Planning - Case Comments

Project Number: PR-2025-020079

Project Name: 1224 Stone Street NE

Request: Minor Preliminary Plat and a DHO Waiver

EXHIBIT B

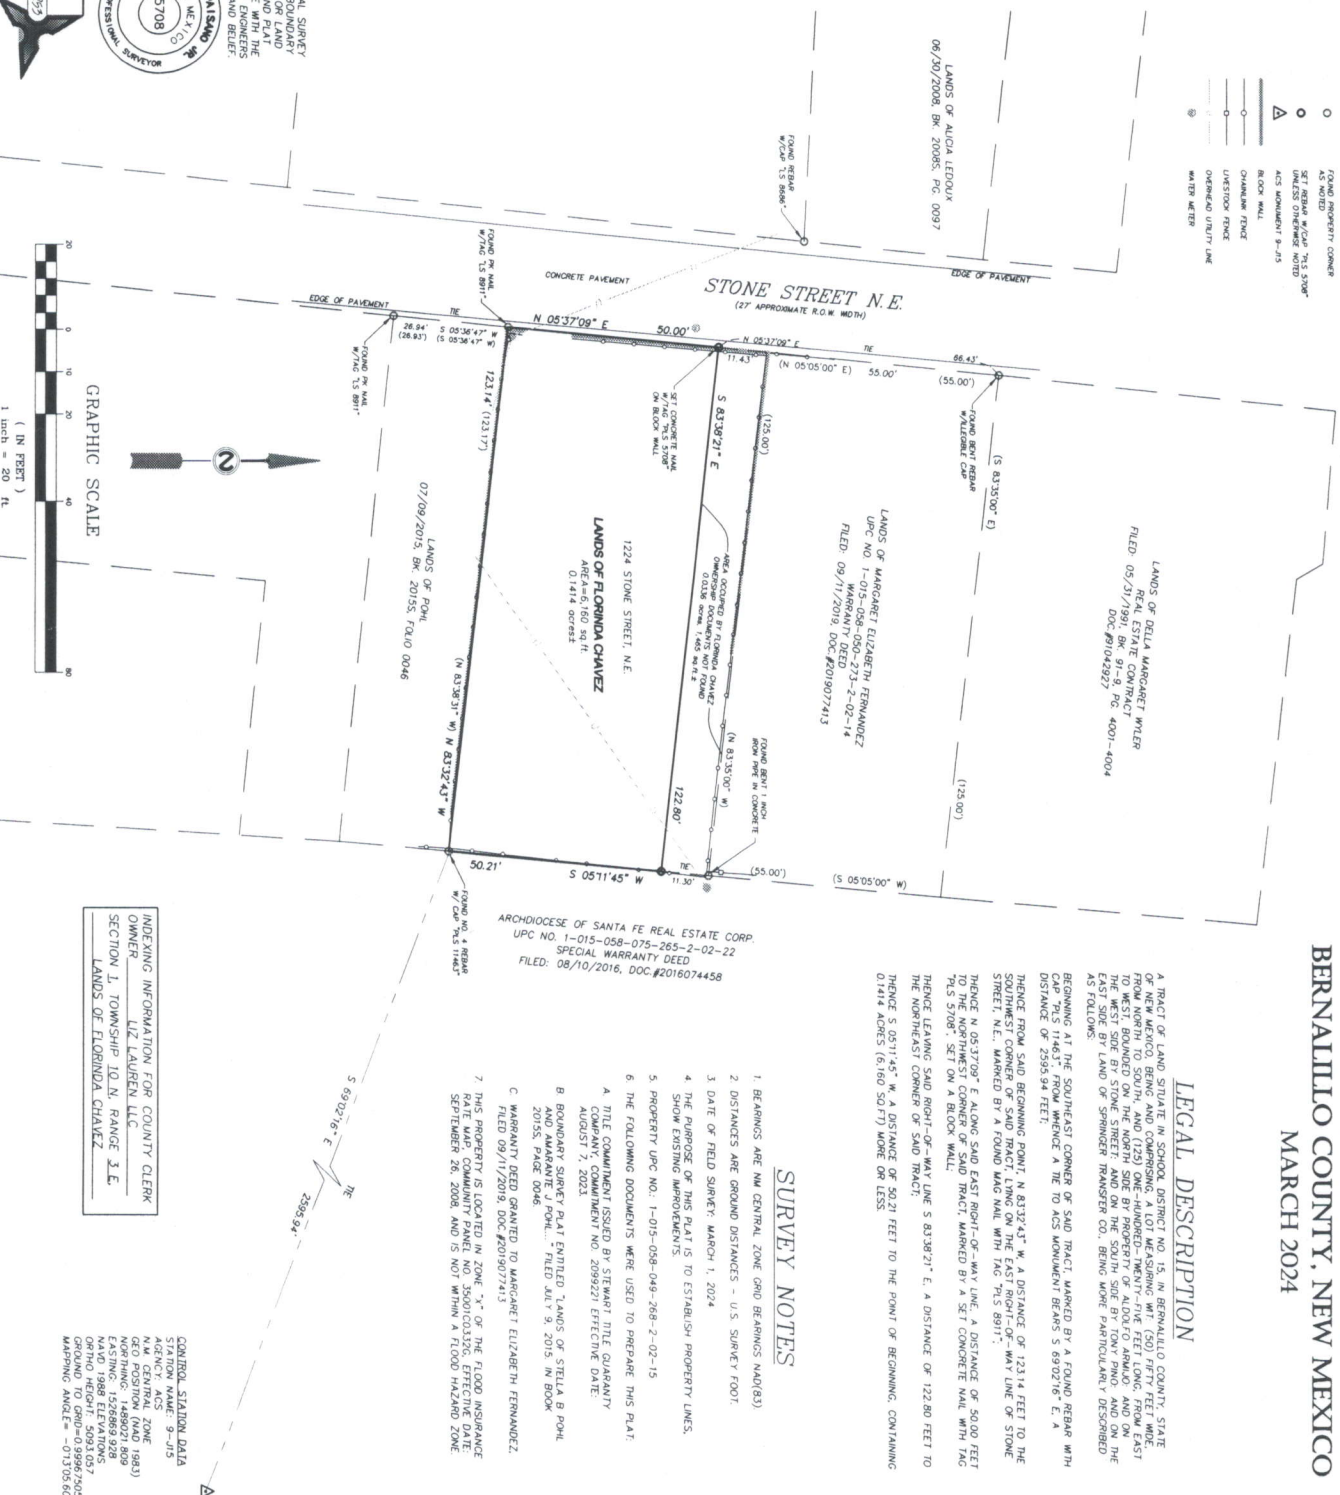
- 
 The proposed Plat features the incorporation of a 11.32-foot portion of property from the abutting property to the north at 1226 Stone Street NE, UPC #: 101505805027320214, that was conveyed by deed from the owner of the property to the north (Mary Elizabeth Fernandez) to Liz Lauren, LLC, but was not previously replatted. Therefore, the abutting property owner(s) for the property to the north of the subject property must sign this Plat, and the boundaries of the property to the north of the subject property must be incorporated into this Plat.

The legal description shown on Sheet 1 and Sheet 2 is inconsistent in formatting and wording. The applicant shall revise the plat so that the legal description is identical verbatim on all sheets, certificates, and supporting documents. Any differences in aliquot calls, wording, abbreviations, or ordering must be corrected prior to approval and recordation.

County record shows 0.188 acres, but acreage on plat must be derived from survey closure, not assessor data. If acreage differs, justification must be included.

**SITE PLAN**  
**TRACT "A"**  
**LANDS OF FLORINDA CHAVEZ**  
 WITHIN NE/4NW/4NW/4SW/4  
 AND SE/4SW/4SW/4NW/4  
 SECTION 16, TOWNSHIP 10 NORTH,  
 RANGE 3 EAST, N.M.P.M.  
 TOWN OF ALBUQUERQUE GRANT  
 CITY OF ALBUQUERQUE  
 BERNALILLO COUNTY, NEW MEXICO,  
 MARCH 2026

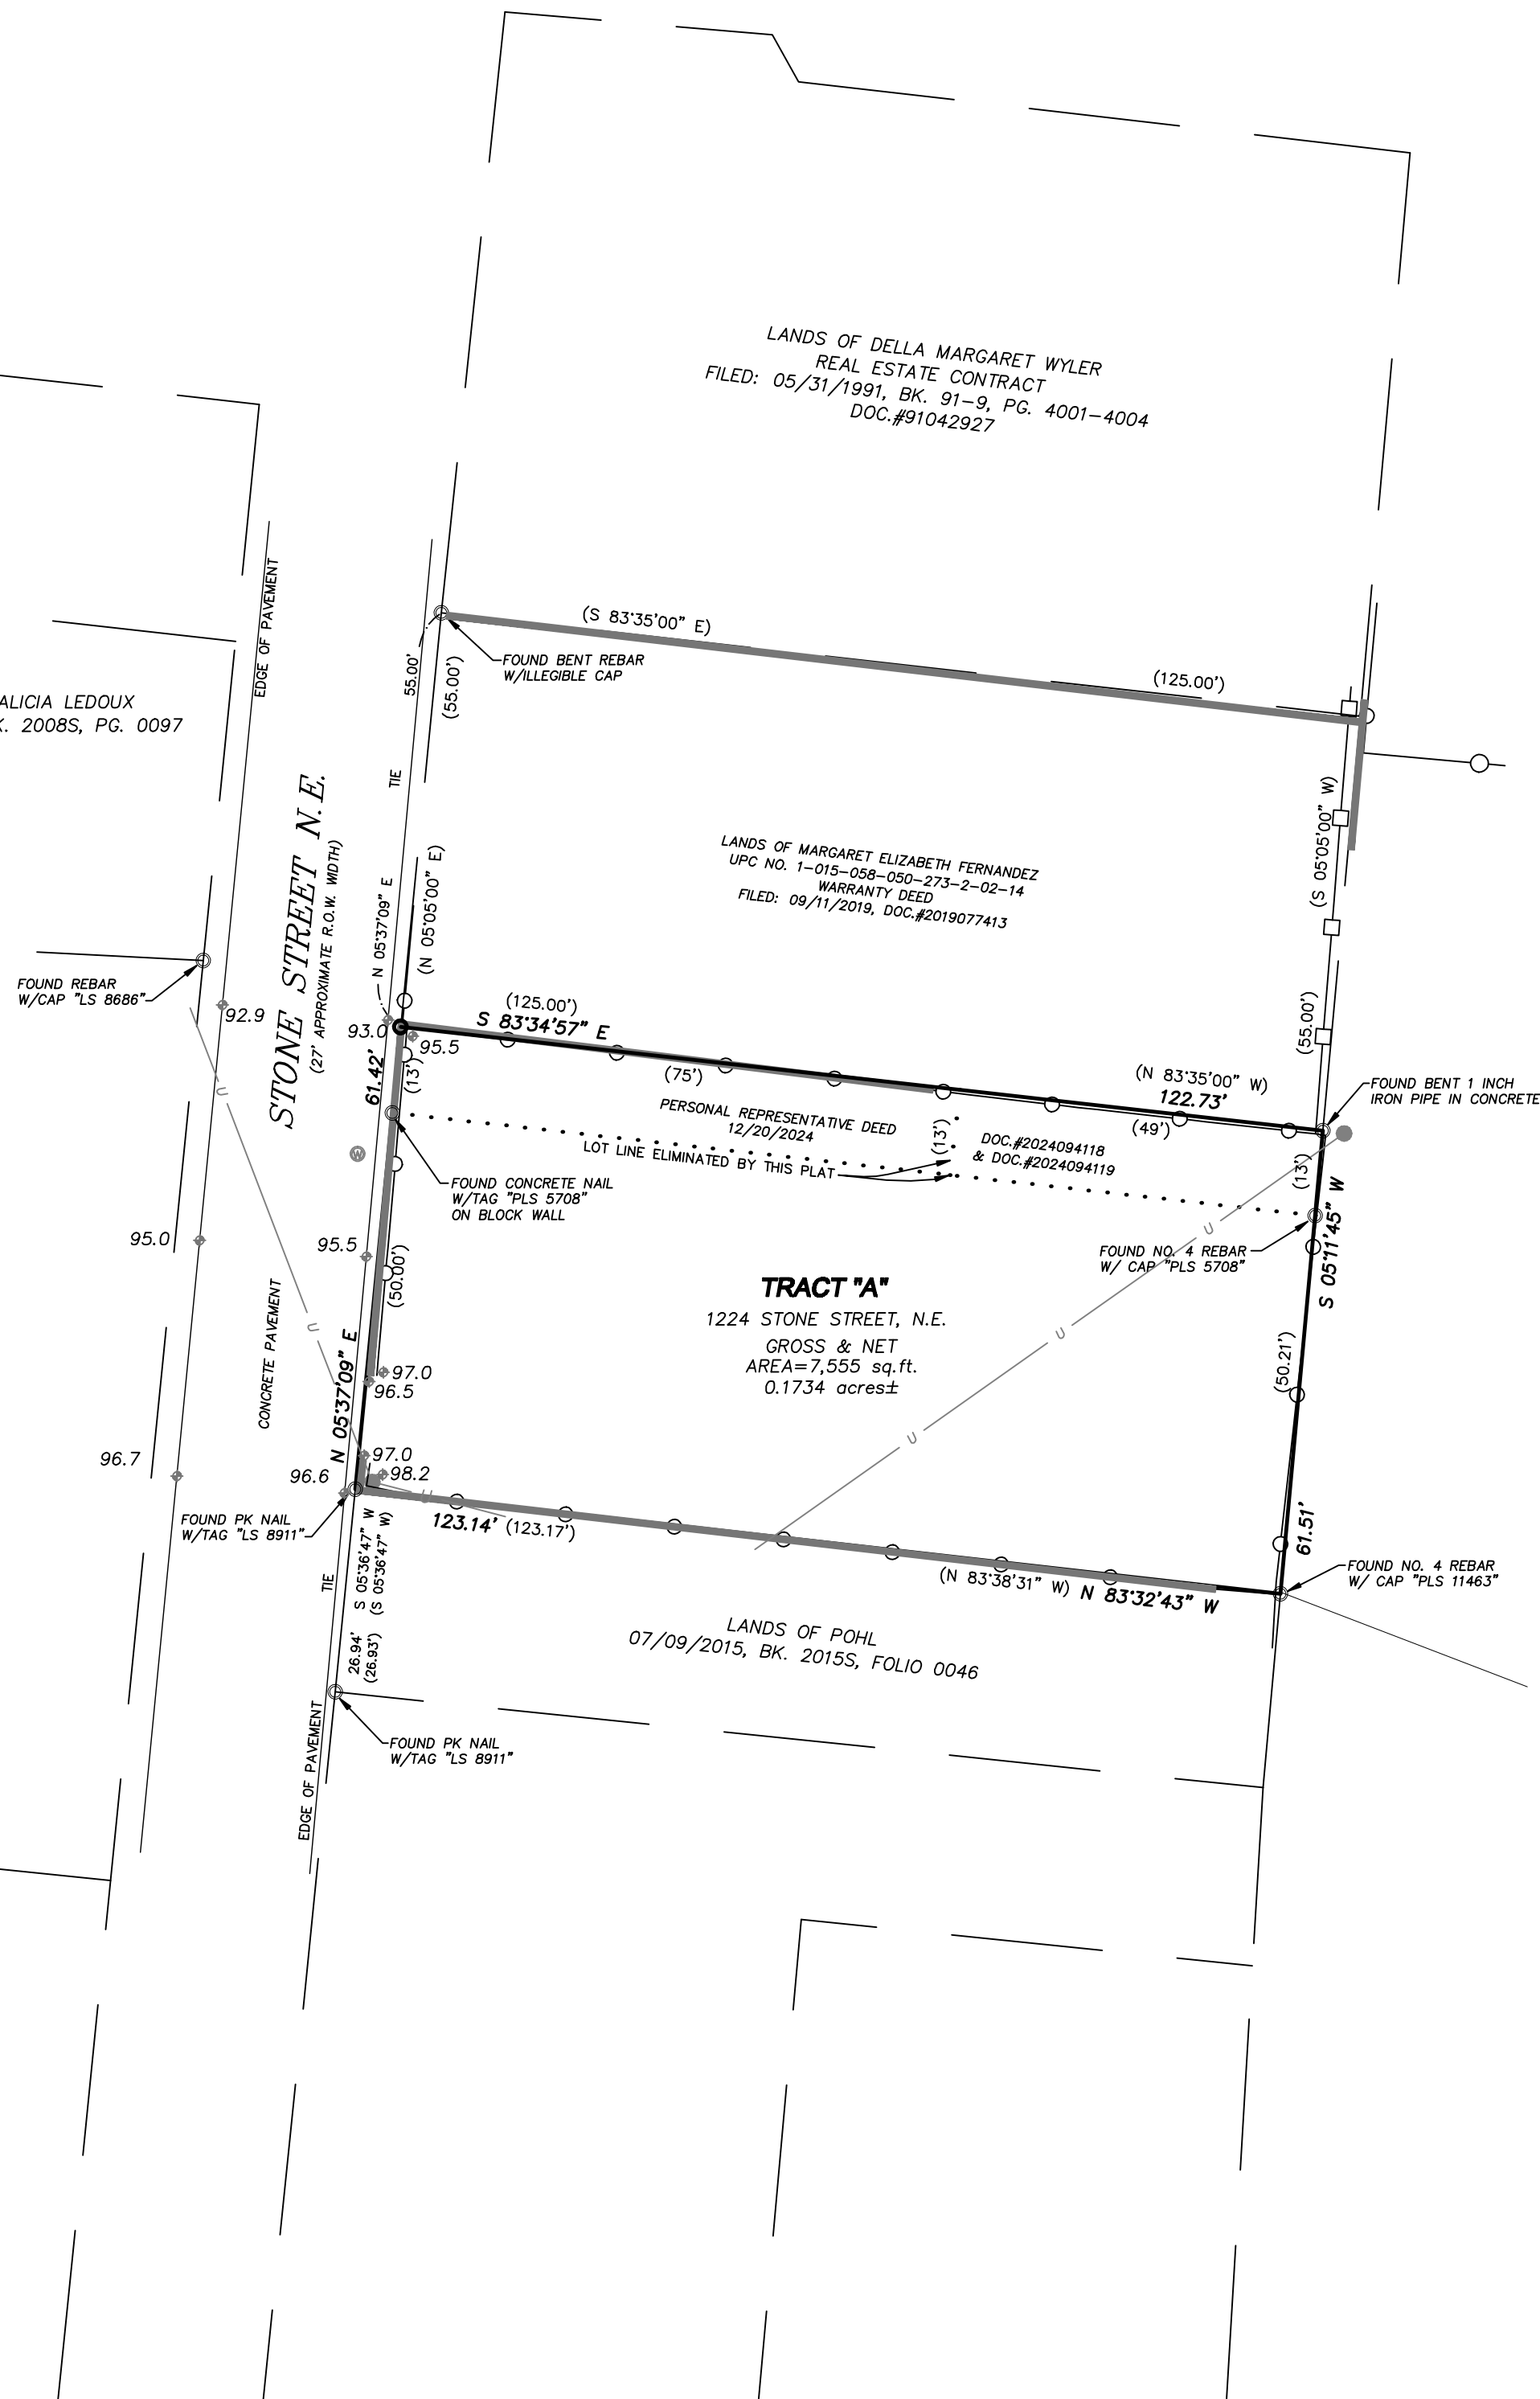
There are pre-existing obstructions that cannot be easily or economically relocated or should not be altered: There is a retaining wall on the front property (east side) that is needed, there is substantial grade difference between the neighbor to the north. There is a utility pole to the south.

- The legal description of the County records does not match the title of the Plat.
